Planning Application Ref: R/66/20/PL

Location: Land adjacent to 19 The Bramblings, Rustington, BN16 2DA

Description of works: Residential development consisting of 1no. new dwelling

DRAWING TITLE			
Site Plan, Street Elevation Block Plan and Location Plan

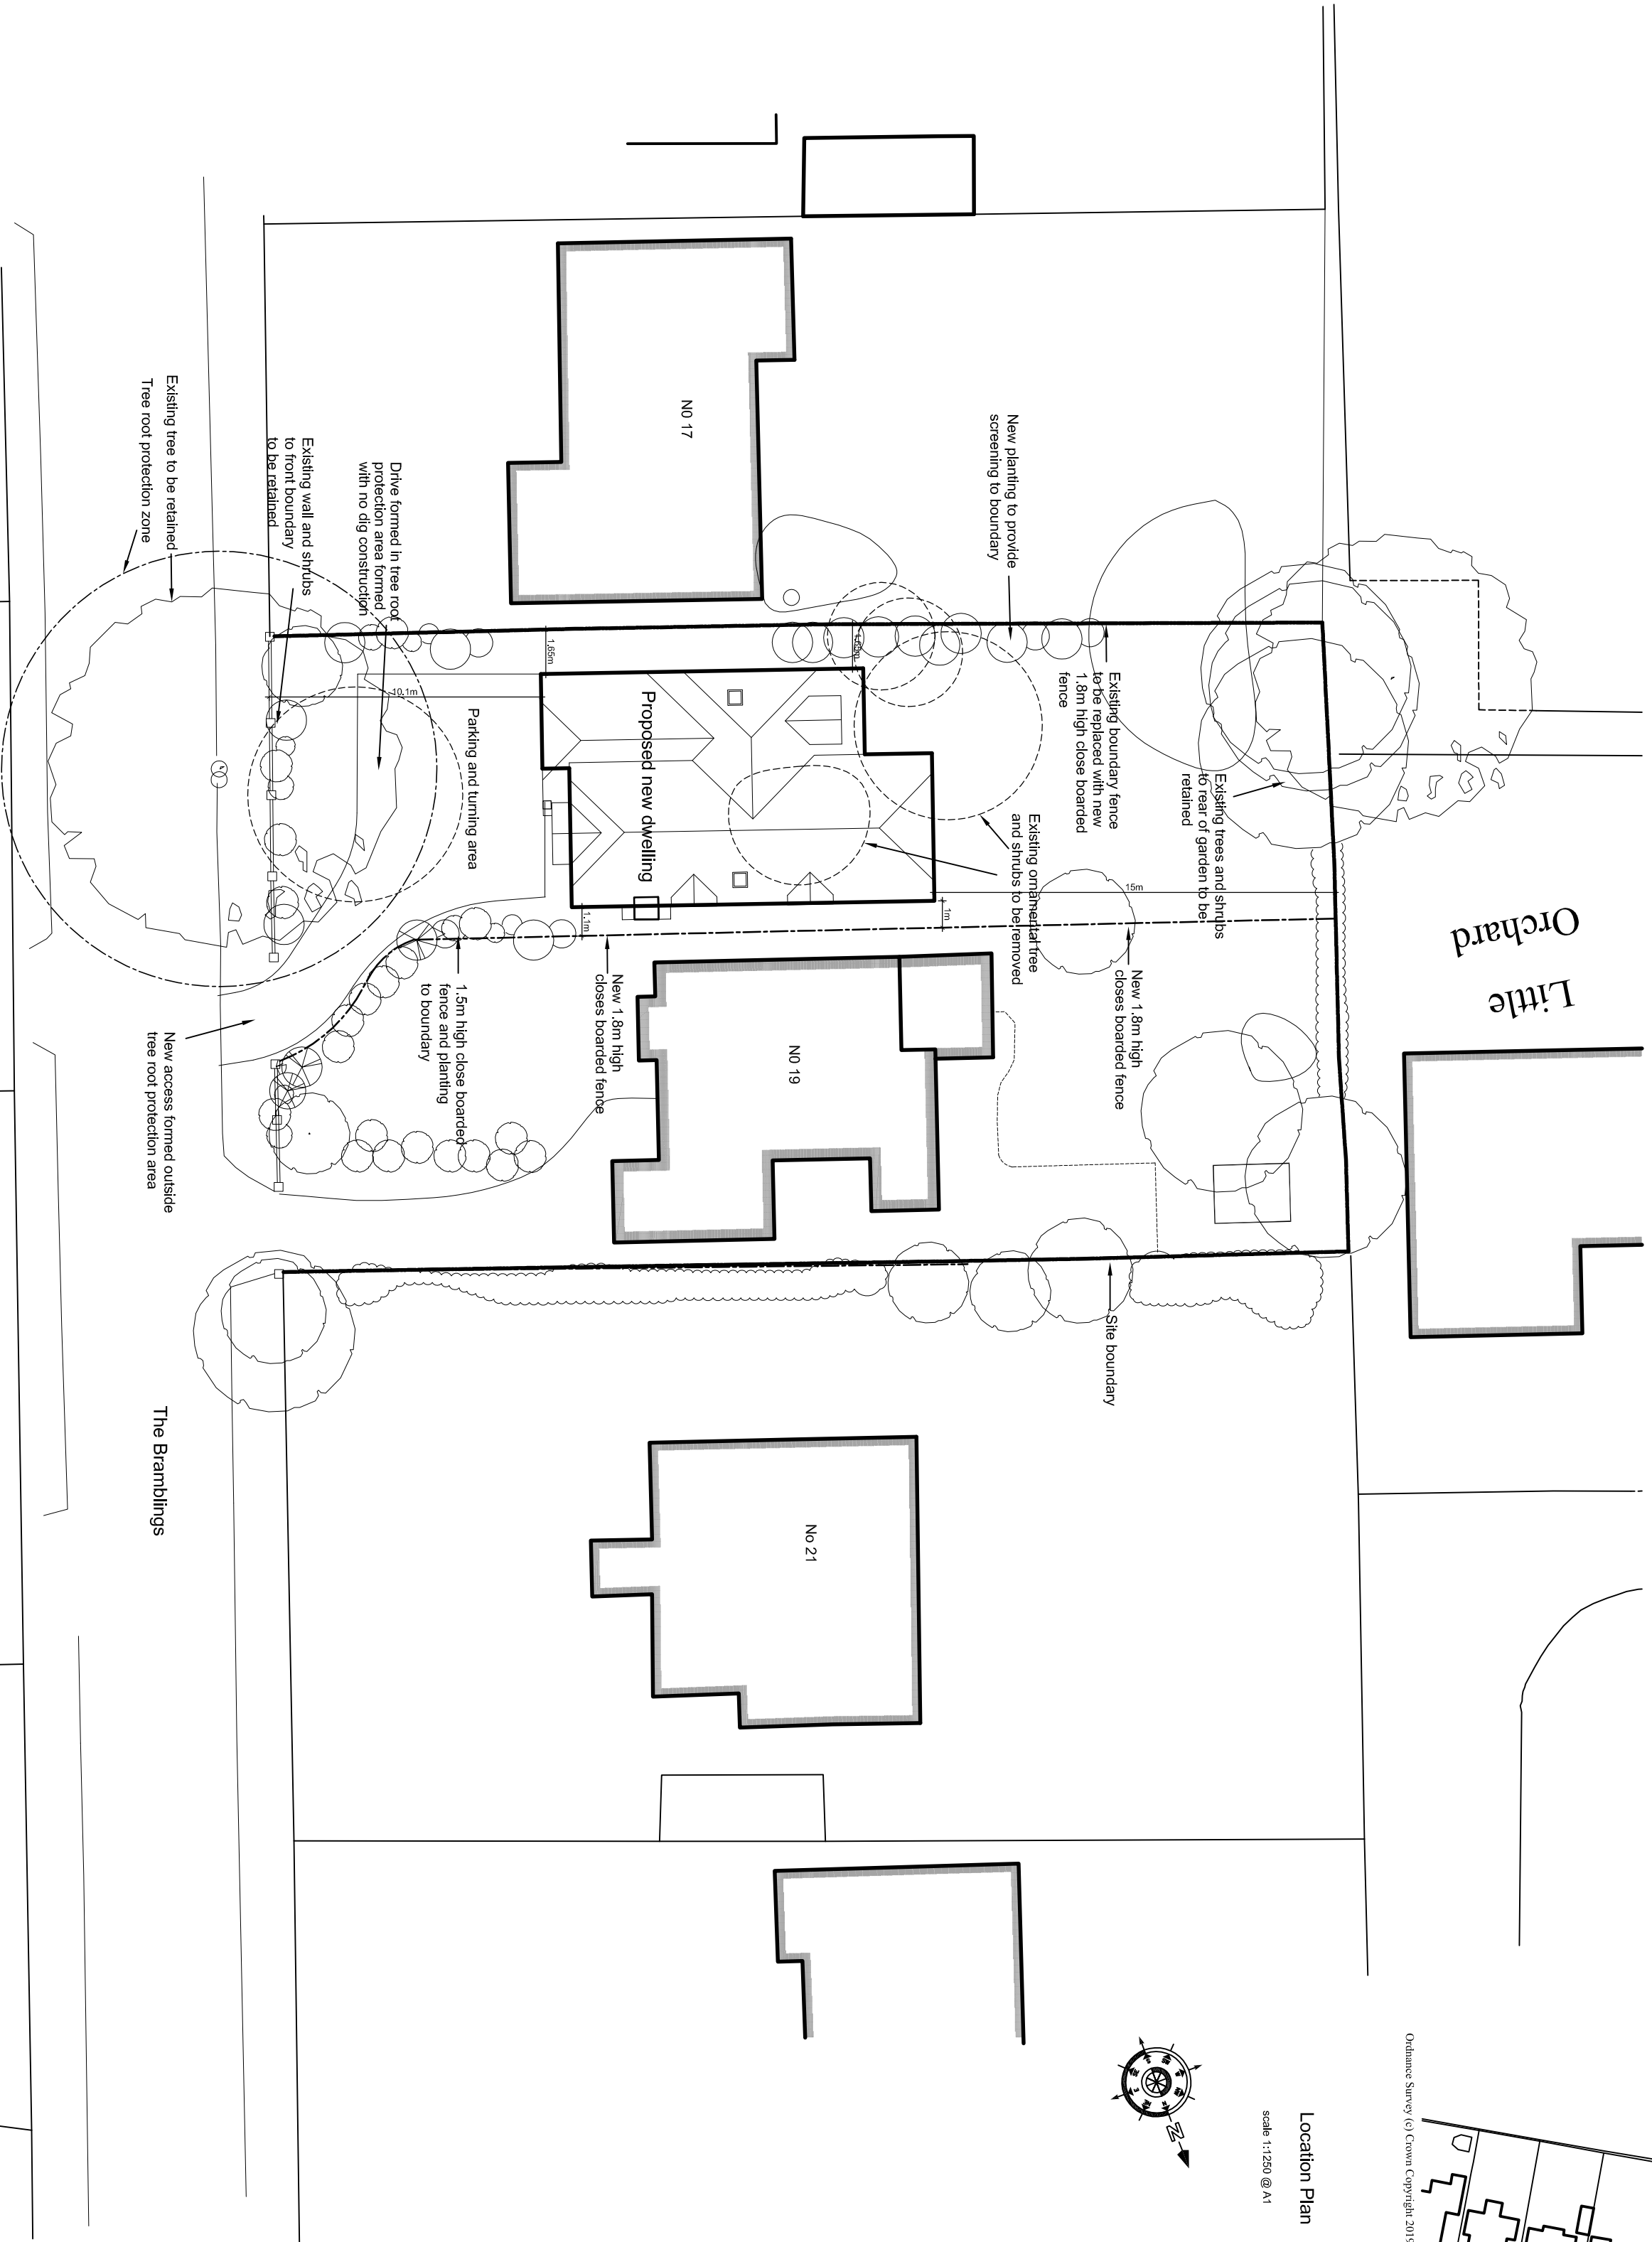
- **Drainage infrastructure and service-runs in and out of site have not been shown** and so there remains a high probability of further root protection area incursion to satisfy those requirements. These elements of the scheme should be described in detail and illustrated on plan drawing(s) and to our satisfaction, prior to any approval.

Drawing Title:
Tree Constraints Drawing

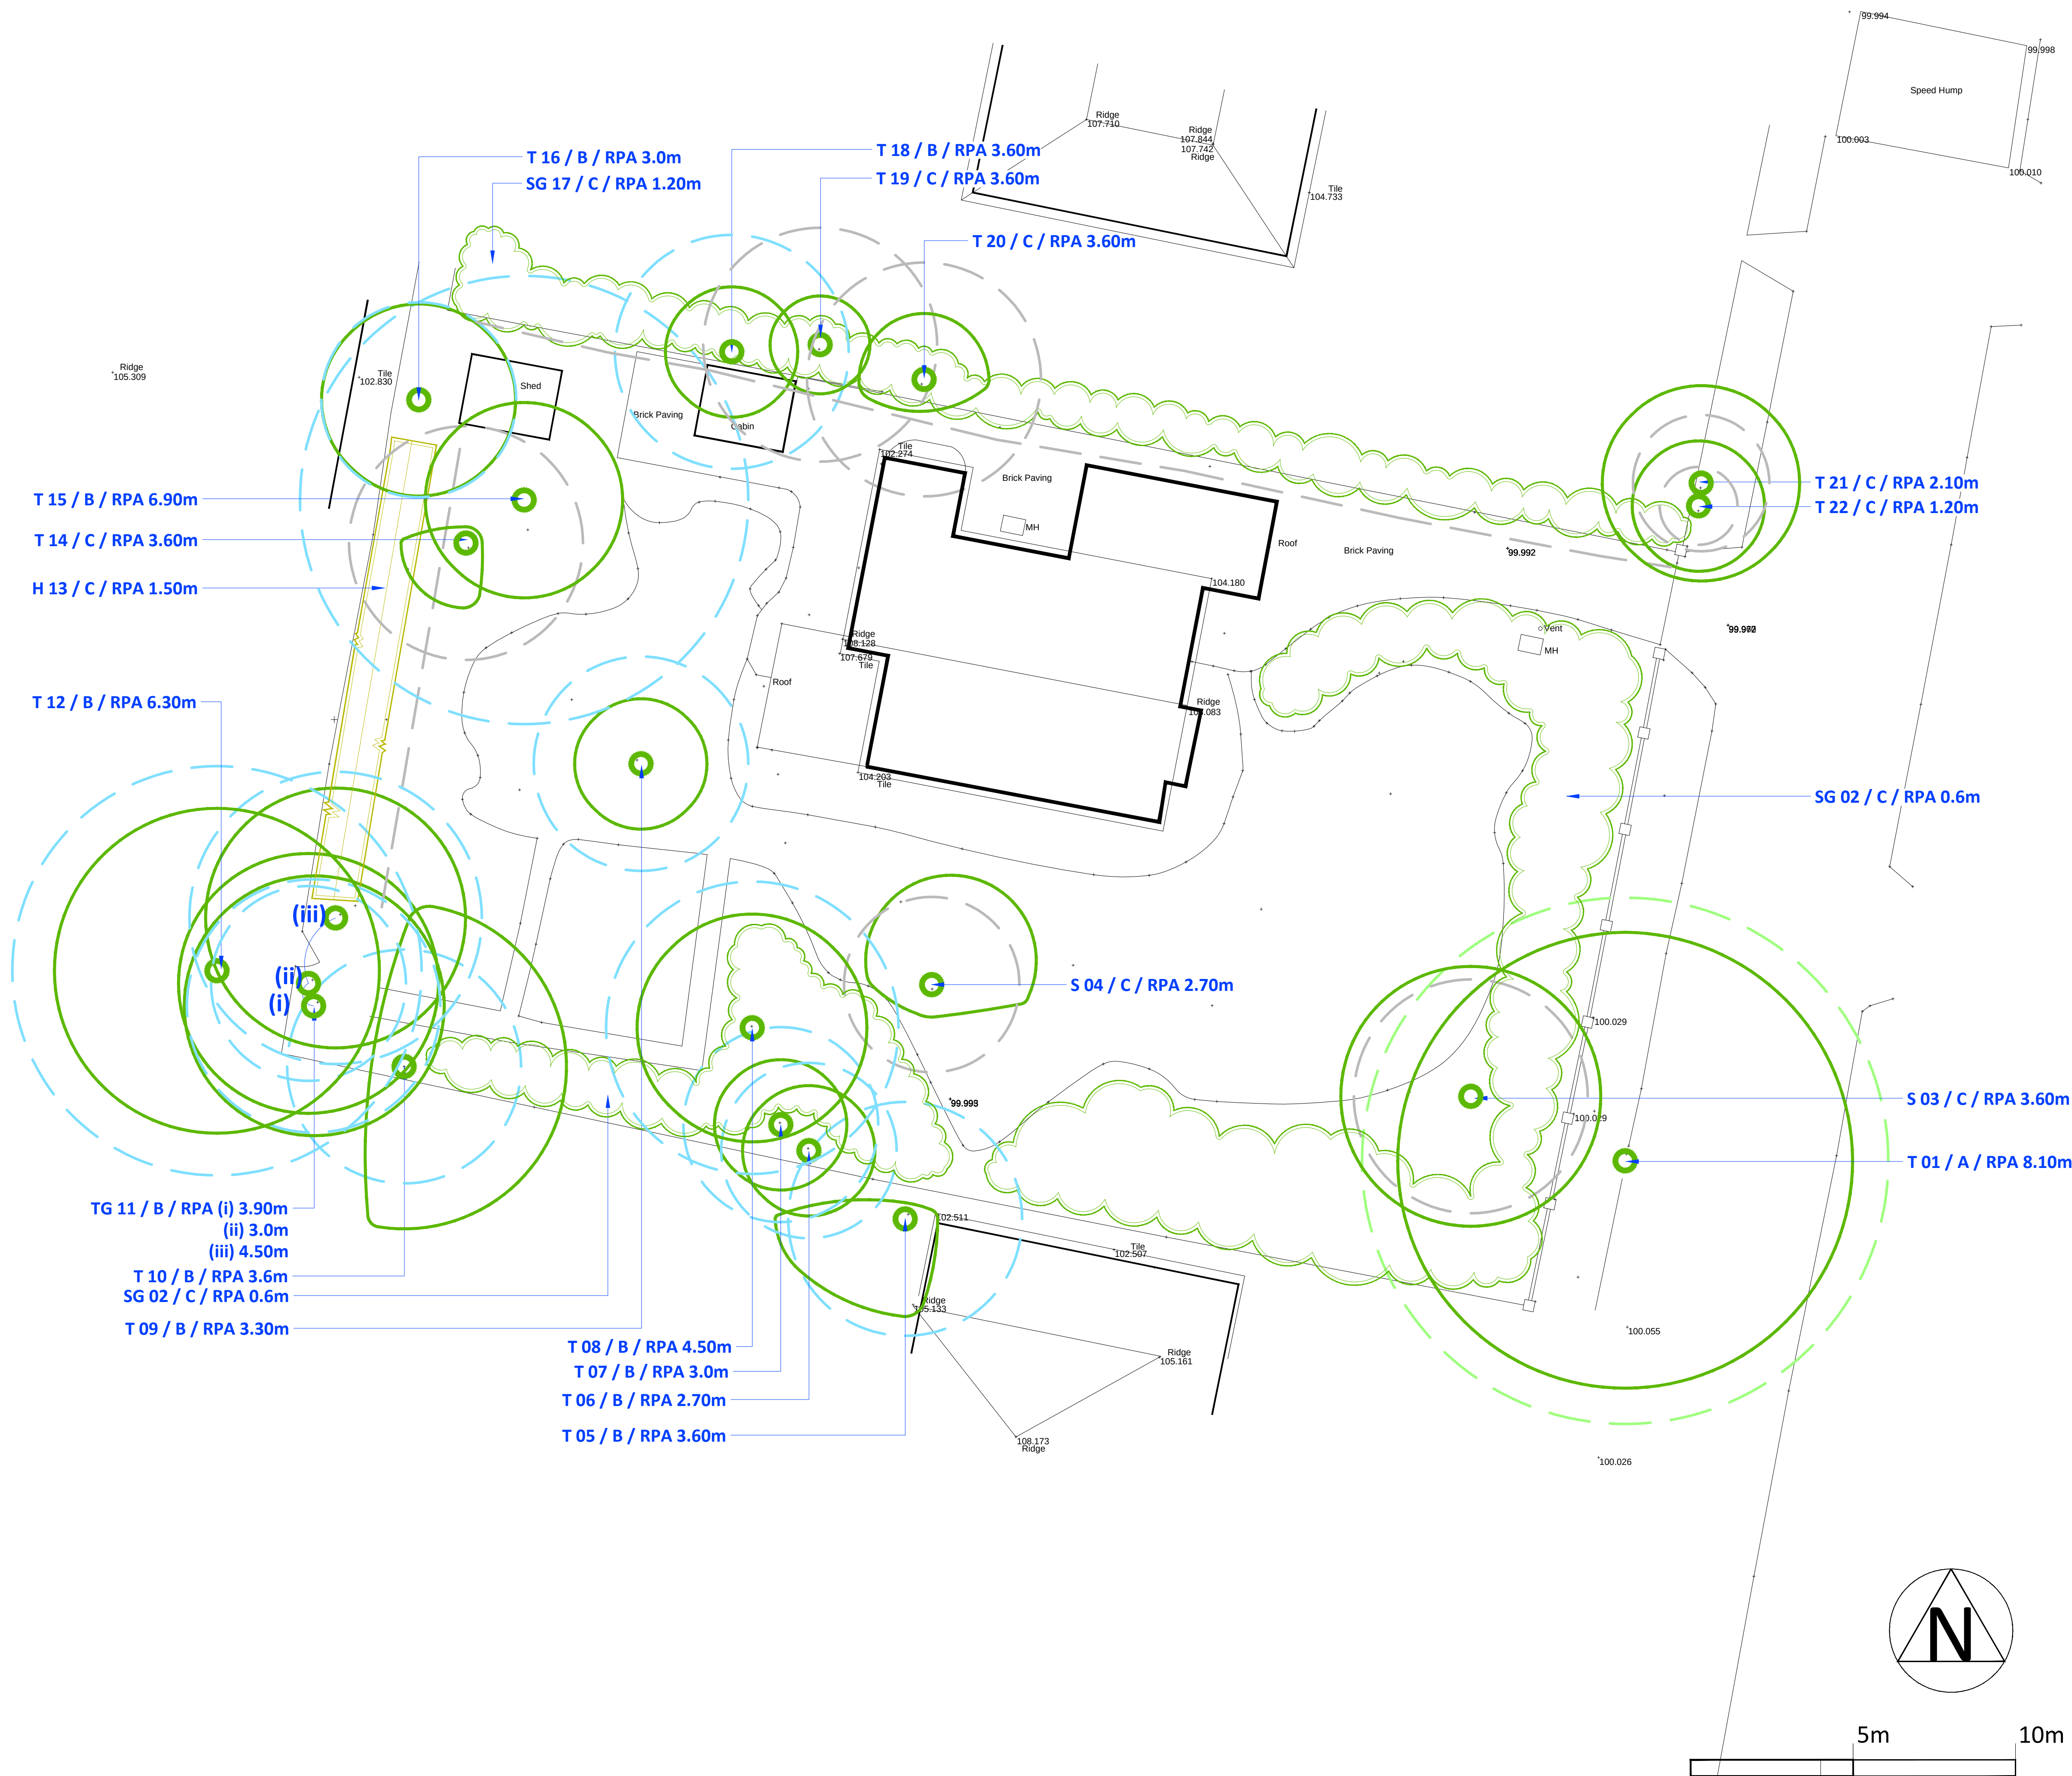
- The use of circular Root Protection Areas is typical and usually adequate but in truth is not always an informative representation in the built environment. With respect to T01, the circle shown does not adequately reflect the required area containing sufficient roots and rooting volume to maintain the tree’s vitality. A revised polygon (of the same area) which abandons the inclusion of much of the carriageway and captures much more of the existing garden and verges would be a more satisfactory representation. **It follows that the actual extent of root protection area intrusion proposed by this scheme is more extensive than that which has been illustrated on the TPP plan. As such, and in the interest of pragmatism, I would support the whole of the driveway construction being constructed by ‘No-dig’ method and to within 2m of the front elevation, with protective fencing extended due west to complement.**
